# ENG-SF19004-R3-FDR-Redlines Summary\_Markup Summary

# ENG-SF19004-R3-CD-Redlines Summary\_Markup Summary

# ENG-SF19004-R3-SC-CD-Redlines Summary\_Markup Summary

# ENG-SF19004-R3-GEC-Redlines Summary

HOMESTEAD AT STERLING RANCH FIL. NO. 2			
SAND FILTER PONDS LOTS 13-24			
PROJECT NO. 09-007	FILE: Yang\Const.Dwg\Street & Storm Plans\ST11.dwg	DATE: 11/19/2019	SHEET 11 OF 14 ST11
DESIGNED BY: CMM	SCALE: 1"=10'	VERT: N/A	
DRAWN BY: CMM	CHECKED BY: VAS

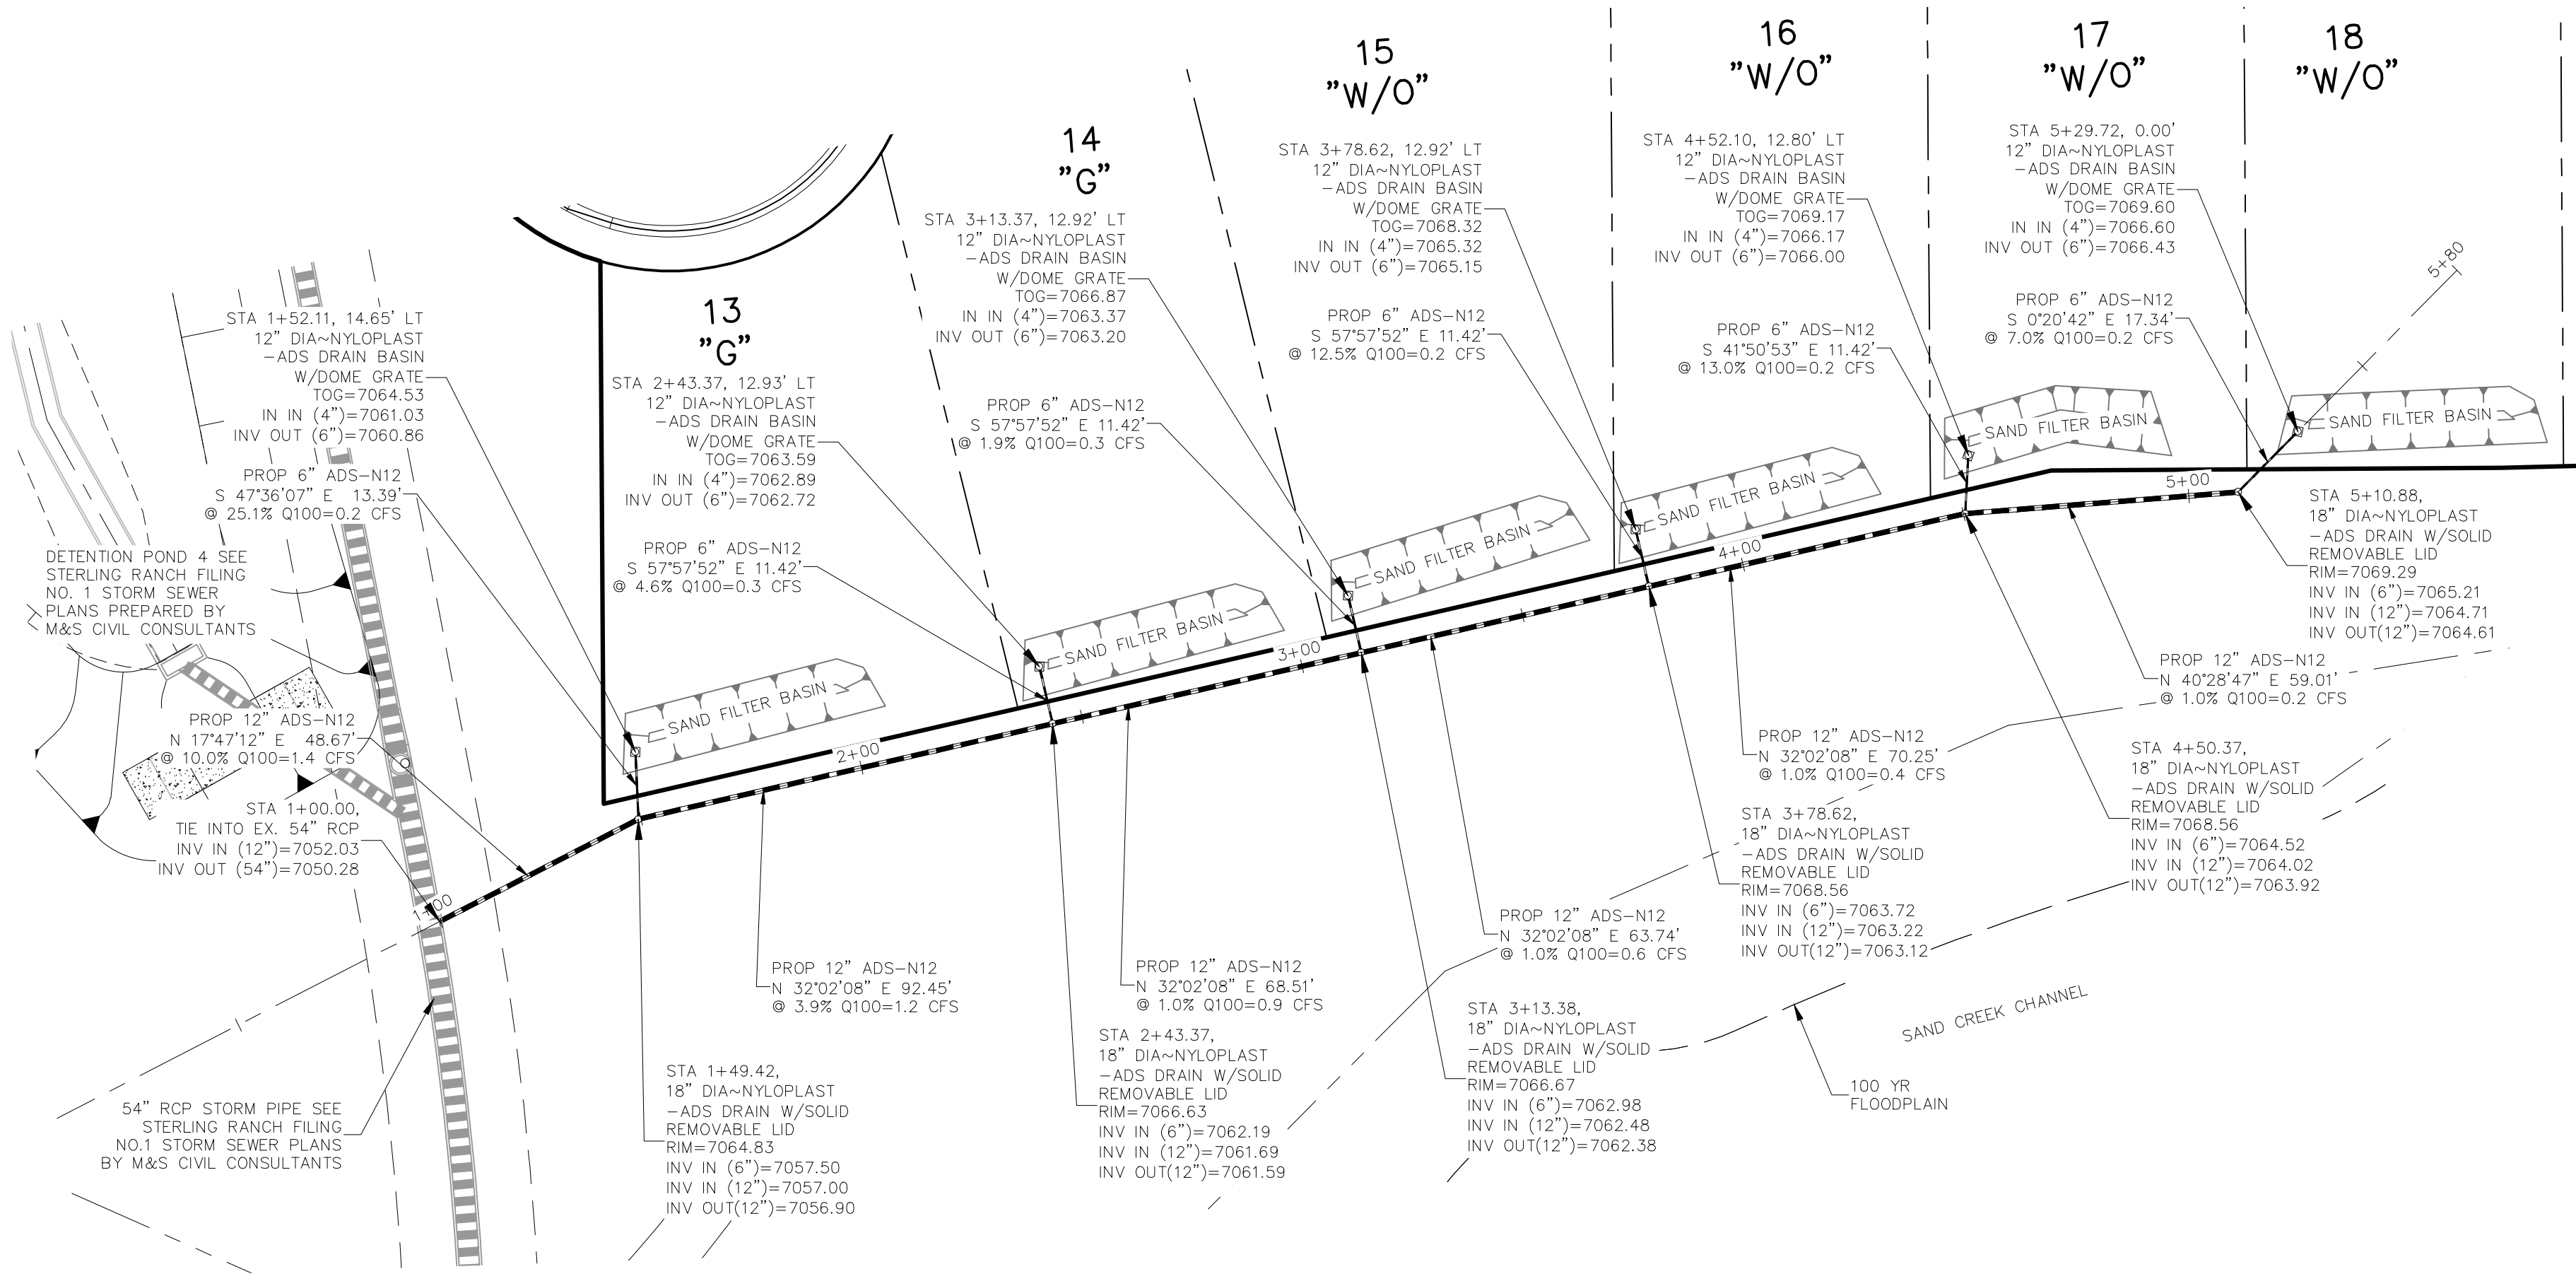
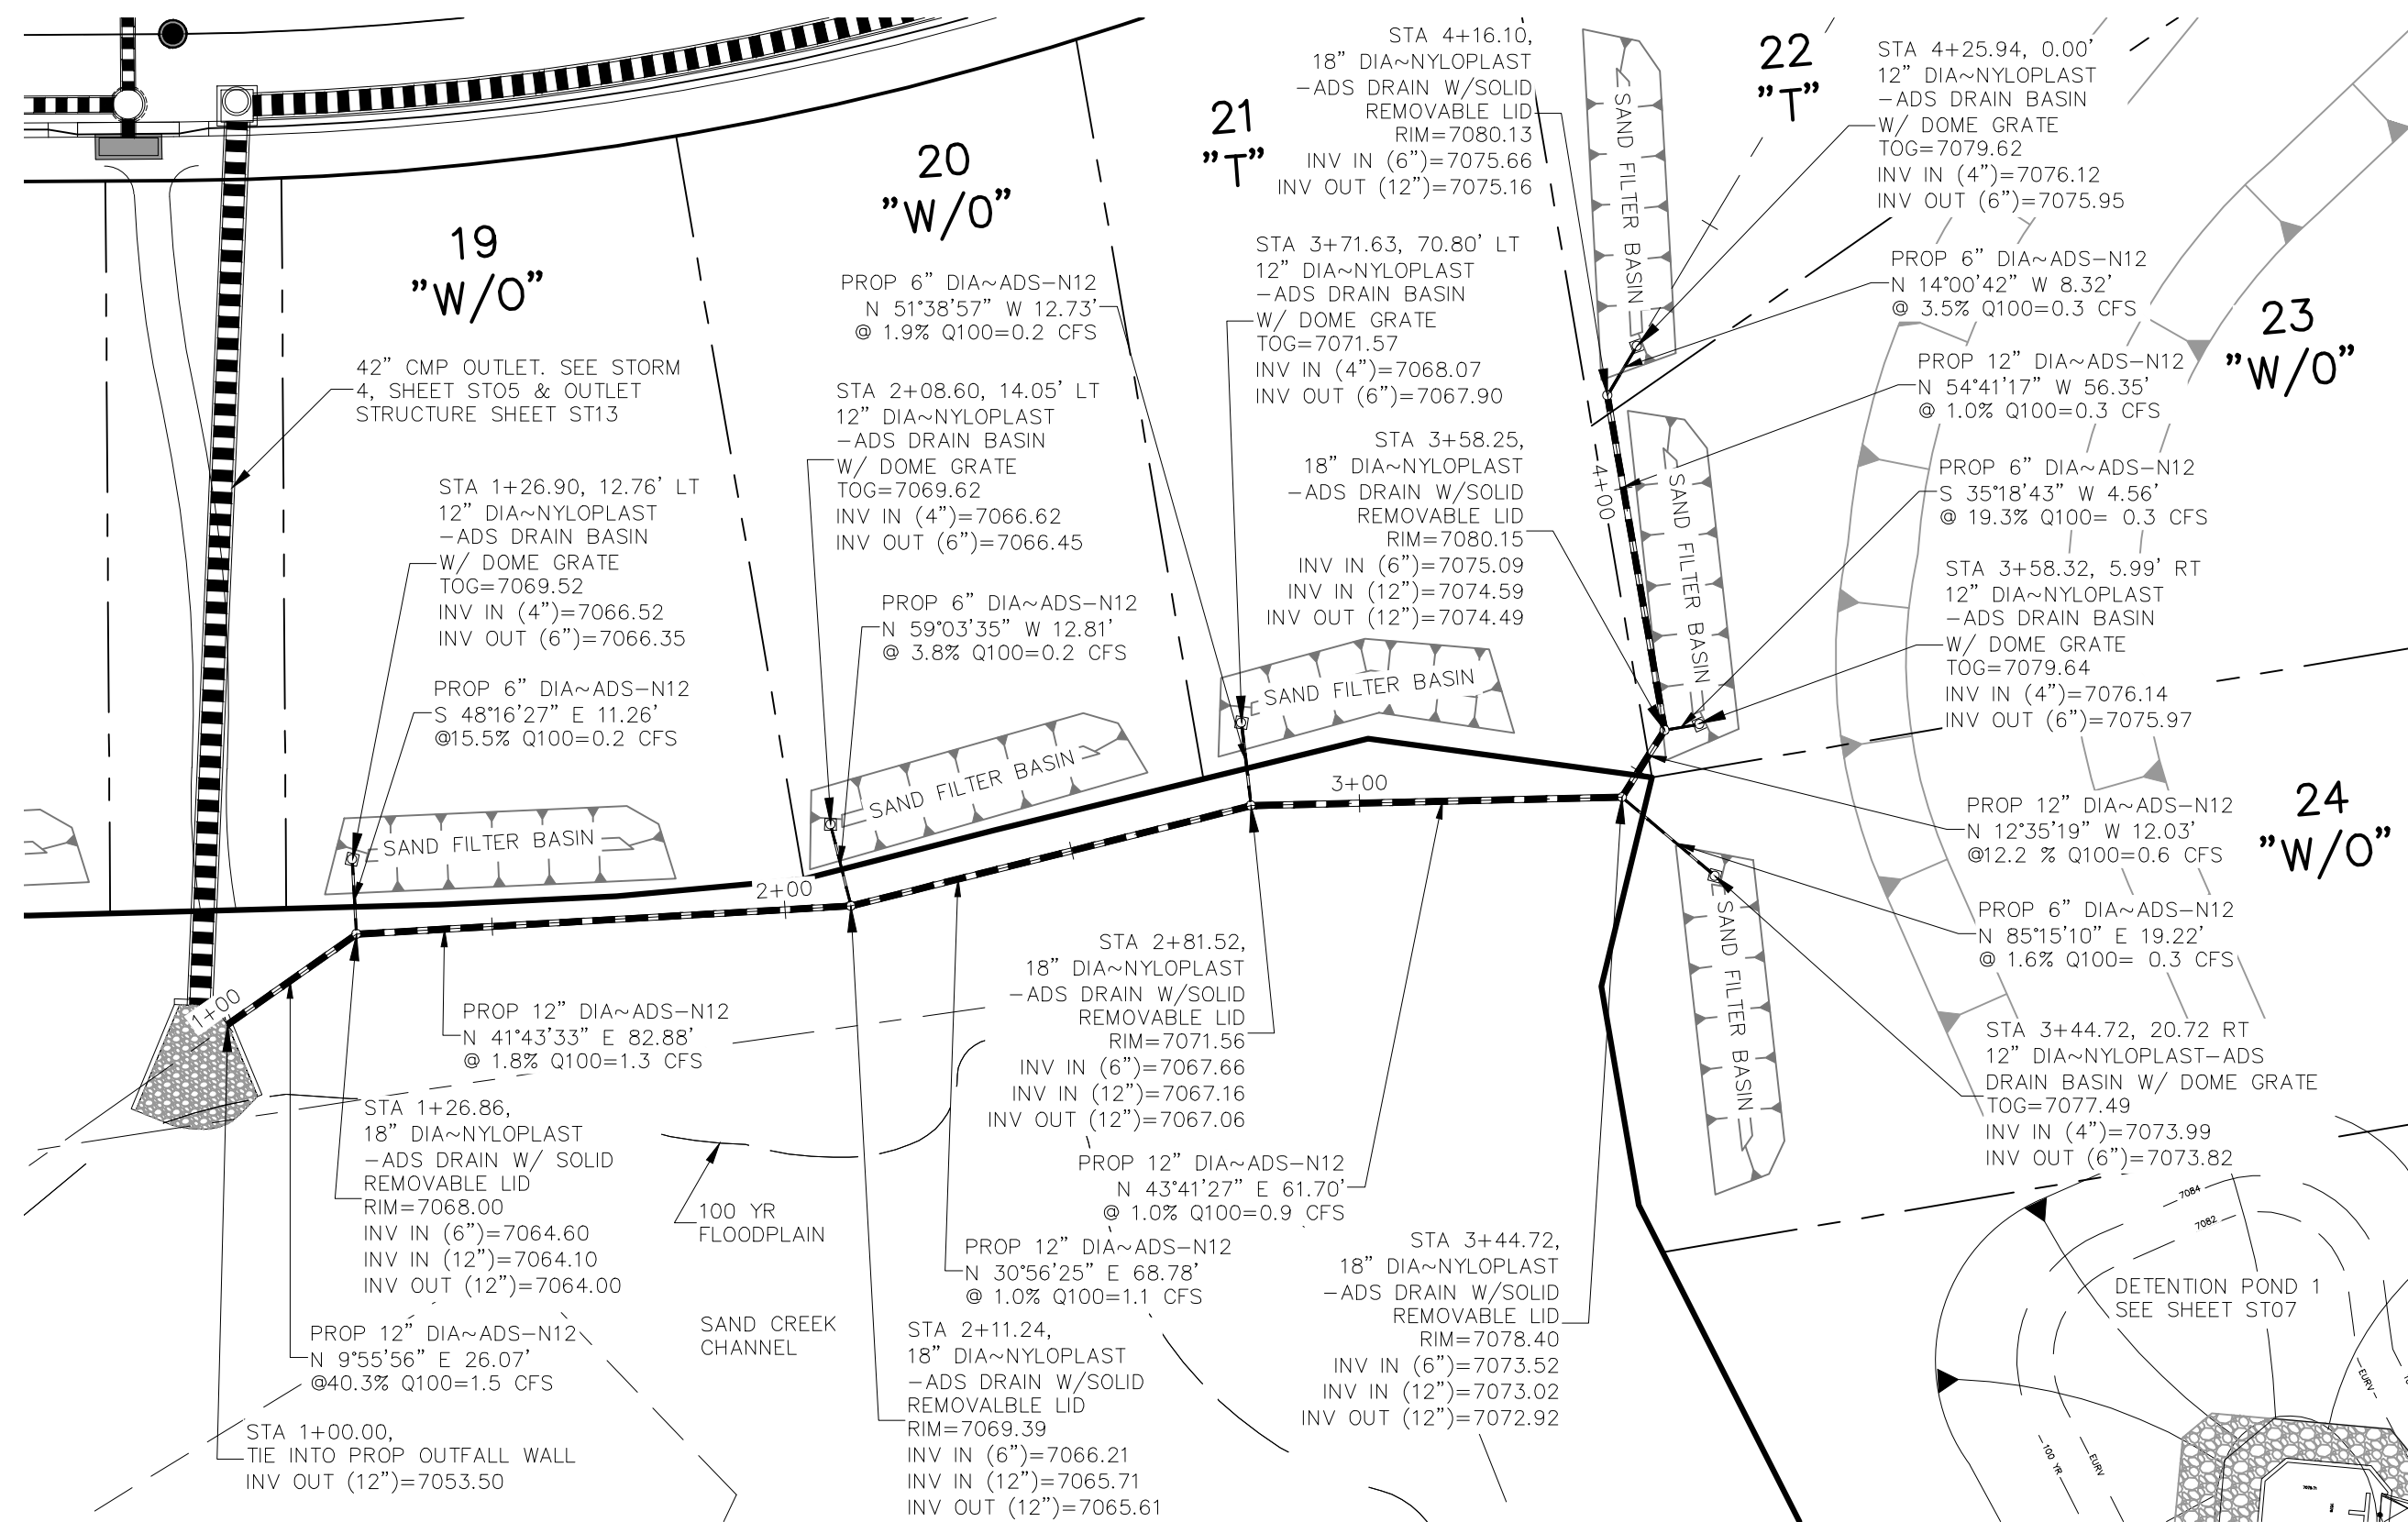
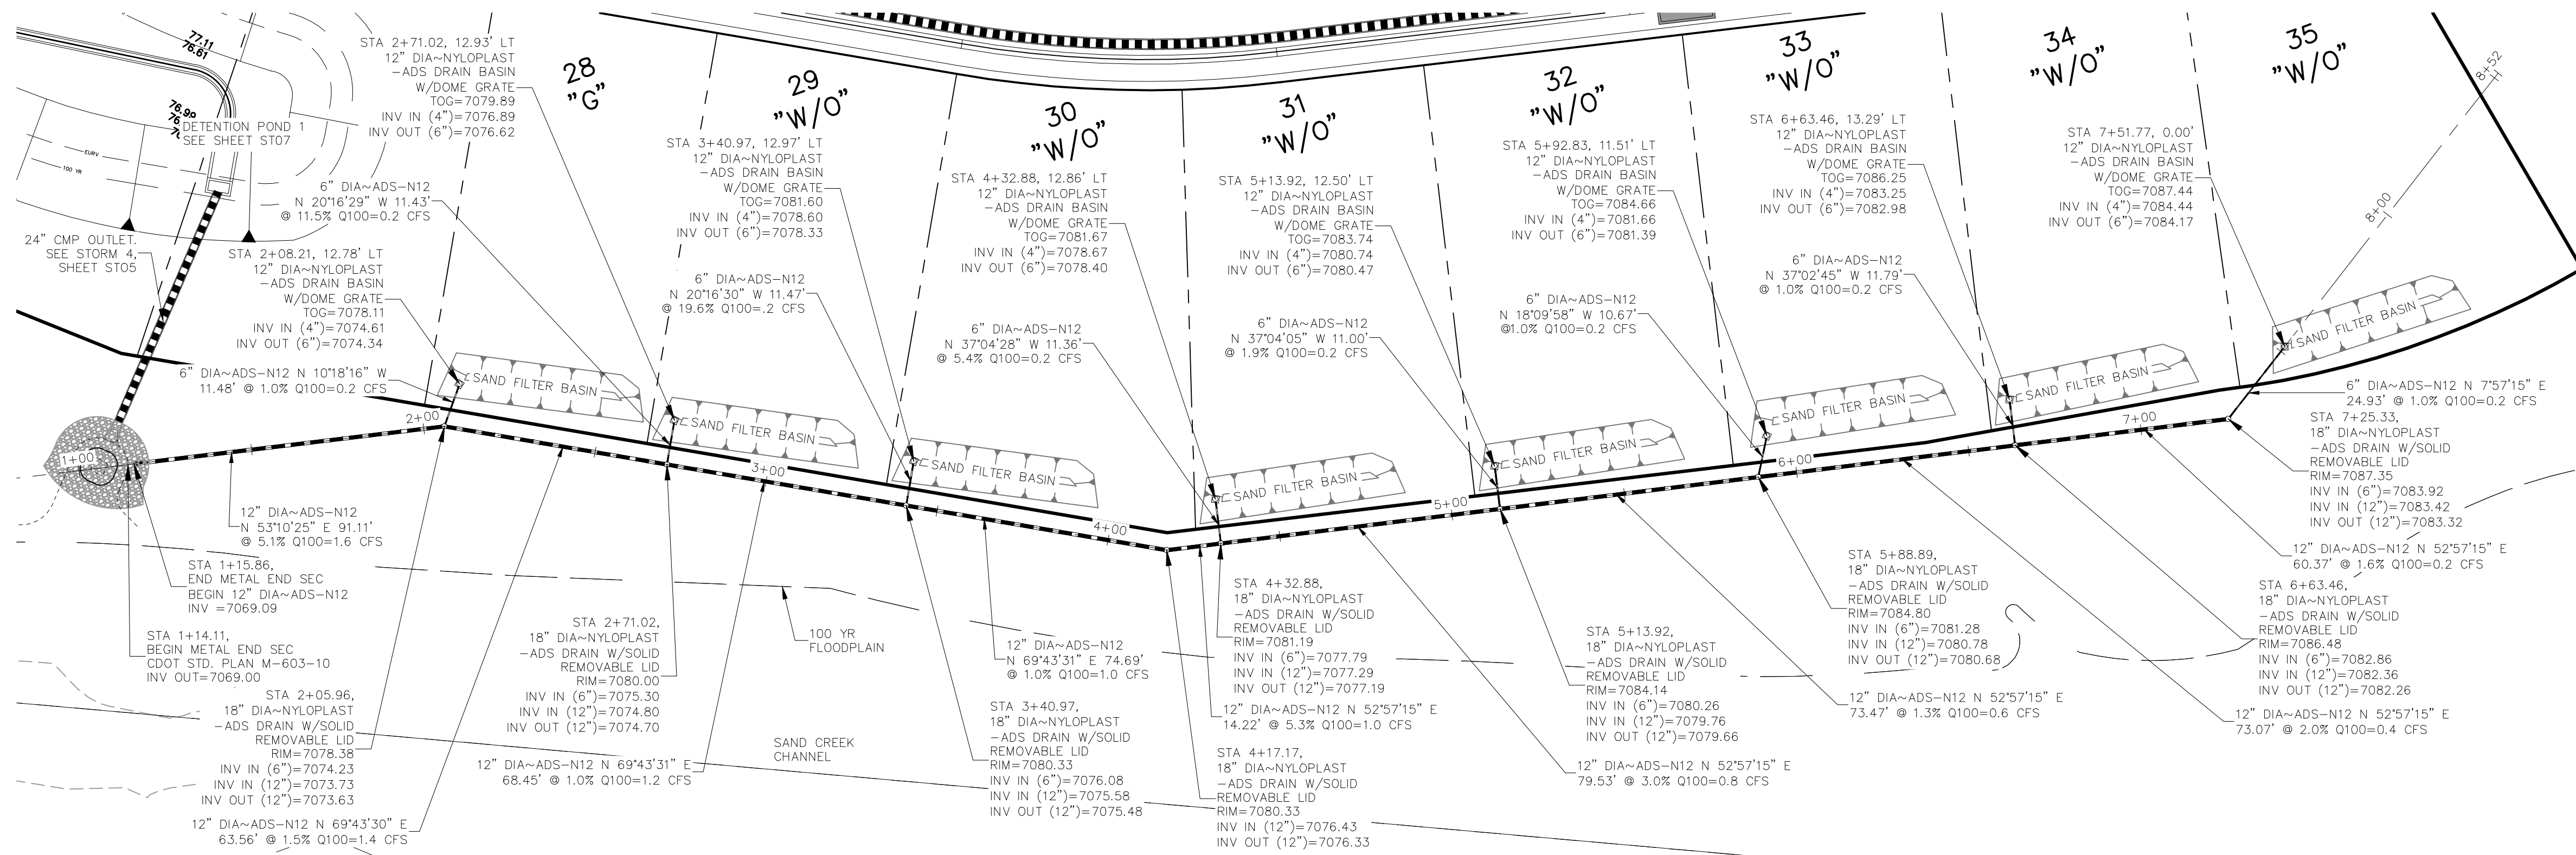
Add a more specific detail for the 52 SFB's that will be used for back yard WQCV. Since all 52 will be similar, provide the outlet structure detail, the outfall pipe sizing information, Fencing, (Split rail fence), etc.
